**Consultation Response from KC,
Highways Development Management - Mark Berry**

2020/93954 Land at, Lingards Road, Slaithwaite, Huddersfield, HD7 5HY

Erection of 42 dwellings and associated works

Date Responded: 29-6-2022

Dwn HH Chkd Date JUL-22 Scale 1:500hor Dwg No. E19/7567/005B 1:100ver@A1

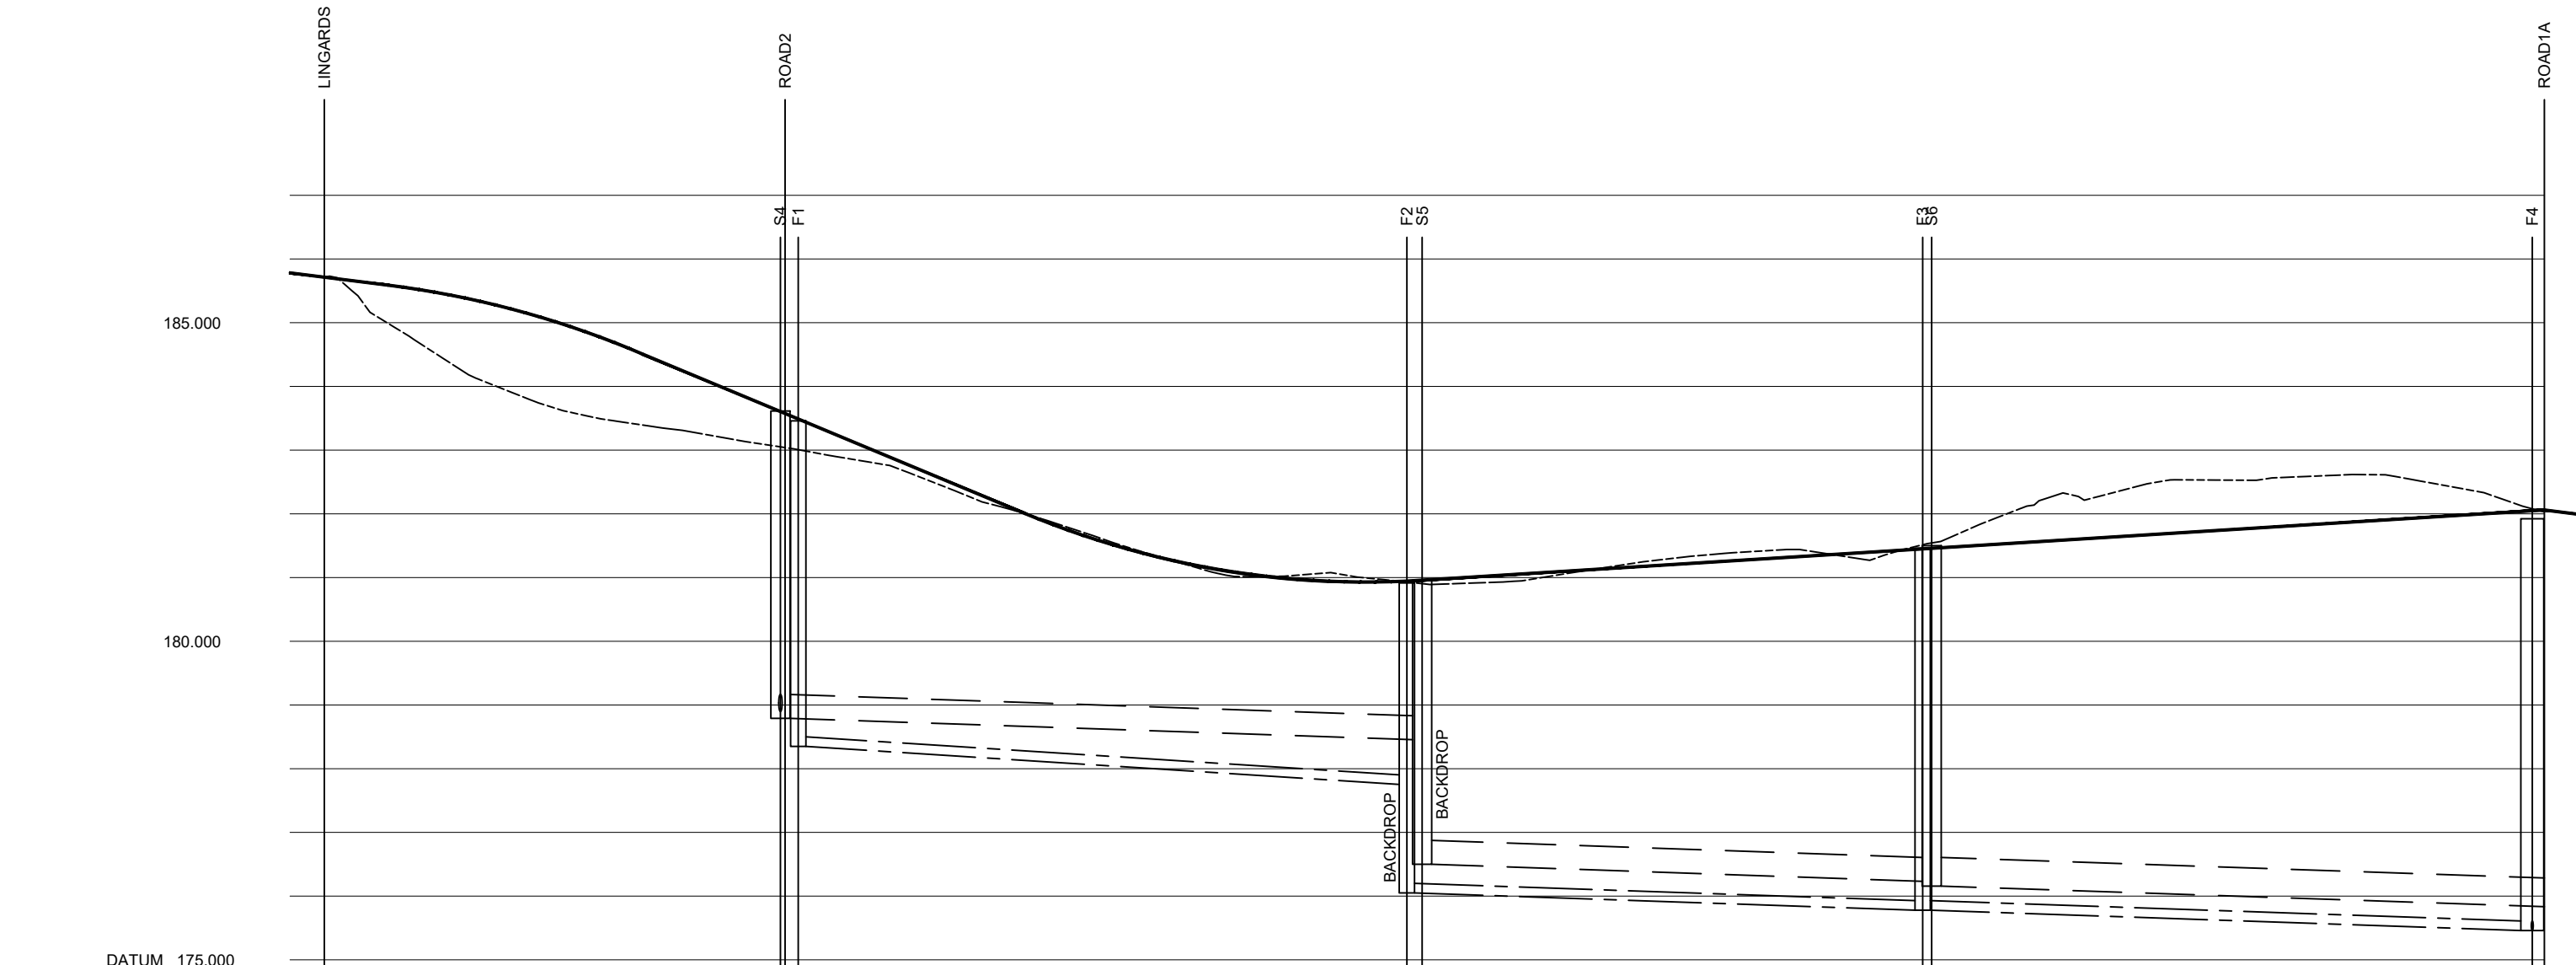
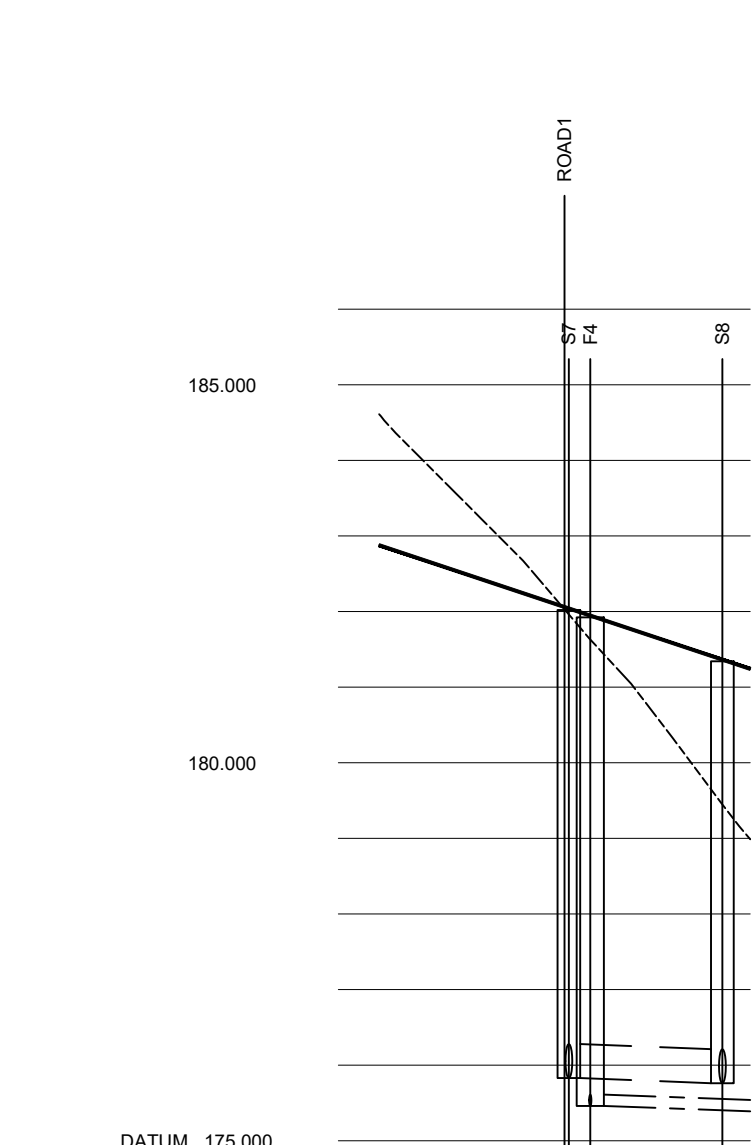
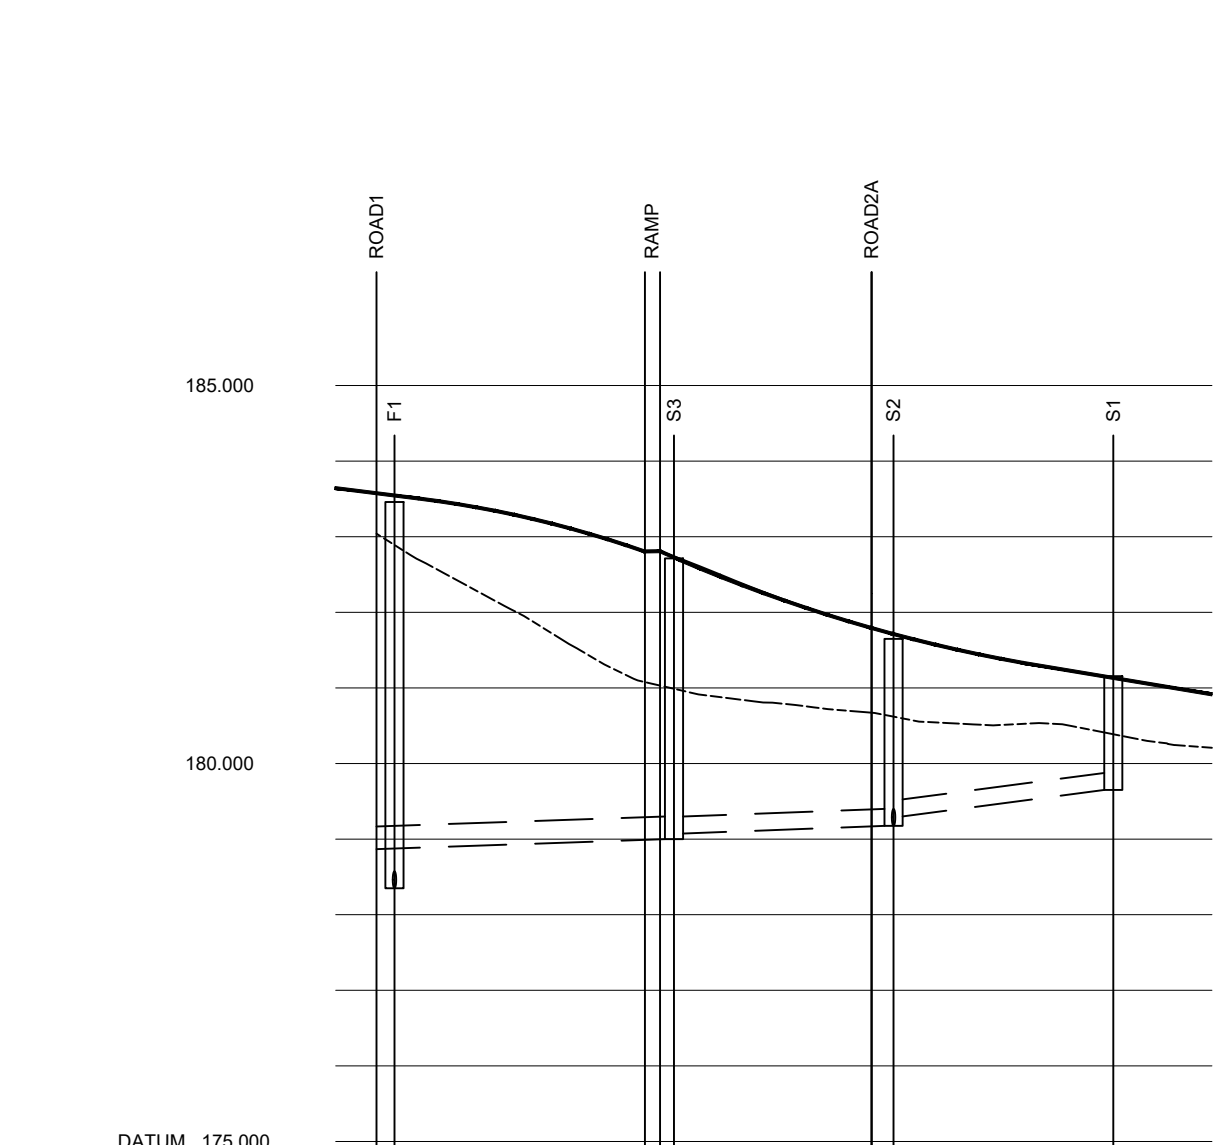
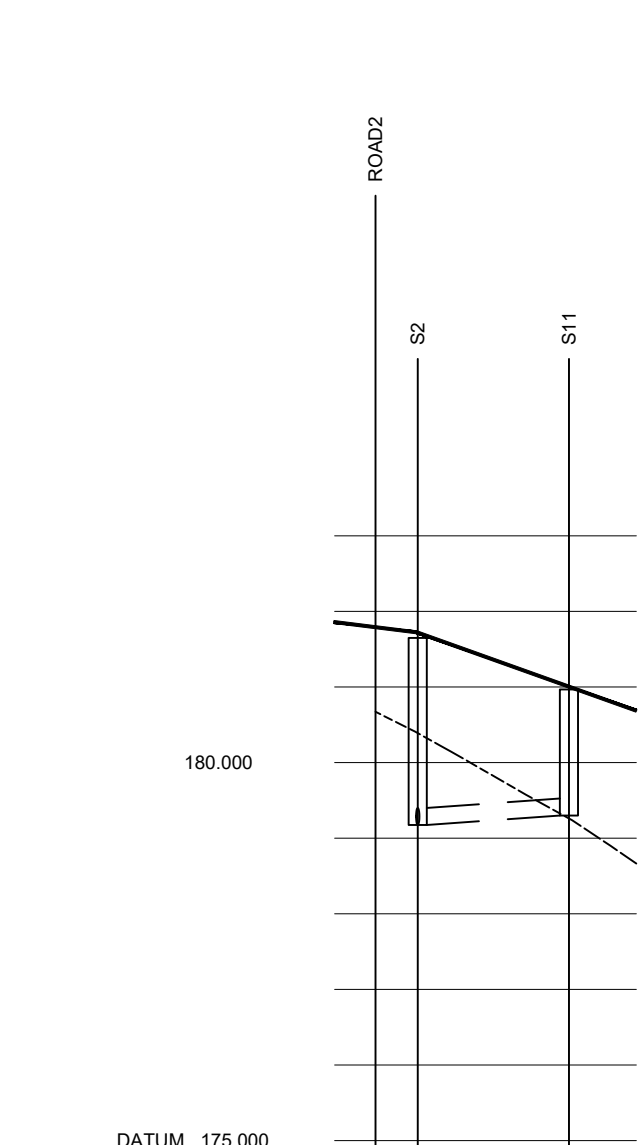
No longitudinal sections are provided to allow the proposed road gradients to be assessed.
